Advice on Modification Report- State Significant Development

Proposal: Birriwa Solar Farm

Major Project reference: SSD-29508870-Mod-1

Attachment A – Detailed Environmental Heritage Advice

Figure 4-4: Birriwa HS01: Shearers' shed and associated farm machinery.

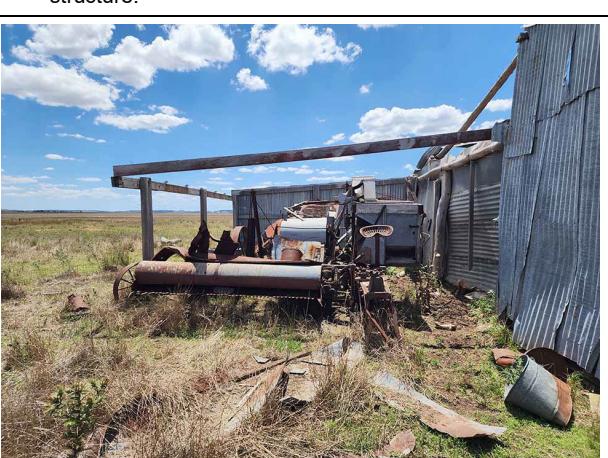
1. Please provide further information and discussion regarding the history of sites *Birriwa Historic Site-01: Shearers Shed* and *Birriwa Historic Site-02: Dilapidated Residence*. In particular:
 - a. Likely association with identified historic phases of the project area
 - b. Likely phase of construction and use of *Birriwa Historic Site-02: Dilapidated Residence*
 - c. Discussion of any specific architectural or construction identifiers (e.g. brick types, architectural styles etc)
2. Please provide additional detail in Section 5.2 discussing why the three identified historic sites don't meet the thresholds of significance

3. Please update the assessment to include a consideration for the potential for archaeological relics in association with the three identified historic sites. The archaeological assessment should include:
 - a. A consideration for the potential for archaeological resources in direct association with the sites, as well as ancillary resources such as further outbuildings, artefactual accumulations, wells etc
 - b. An assessment of significance of any potential archaeological resources against the relevant guidelines
 - c. Proposed recommendations and mitigation measures relevant to any identified archaeological relics and proposed impacts from the modification
